KITTITAS COUNTY DEPARTMENT OF PUBLIC WORKS

MEMORANDUM

TO: Jeff Watson, Community Development Services
FROM: Christina Wollman, Planner II *cw*
DATE: February 5, 2013
SUBJECT: Barnes Short Plat SP-12-00008

BARNES SHORT PLAT KITTITAS COUNTY SHORT PLAT NO. SP-12XXXXX A PORTION OF THE NE 1/4 SECTION 5, TOWNSHIP 16 NORTH, RANGE 20 EAST, W.M., KITTITAS COUNTY, WASHINGTON

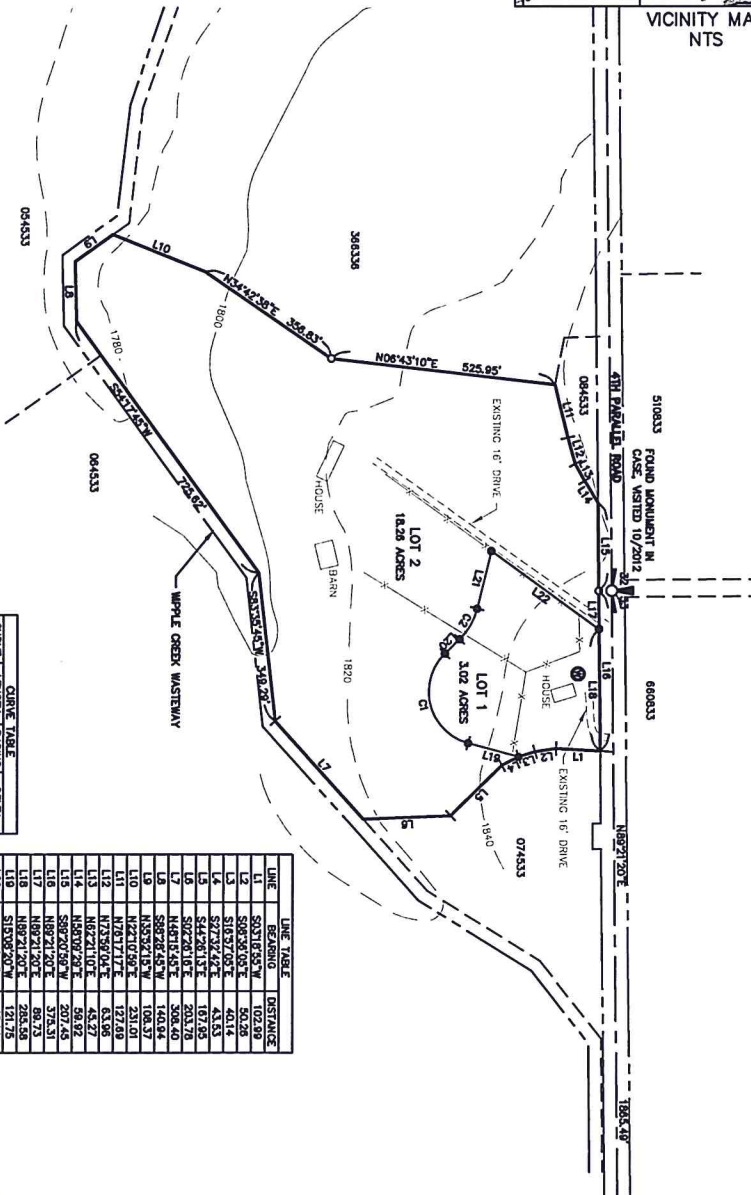
1. Single-Use Driveway: A single-use access shall serve no more than one lot. See Kittitas County Road Standards, 9/6/05 edition.
 - a. The roadway shall be a minimum of 8' wide with gravel surface.

- b. Maintenance of driveway approaches shall be the responsibility of the owner whose property they serve. The County will not maintain accesses.
 - c. Any further subdivision or lots to be served by proposed access may result in further access requirements.
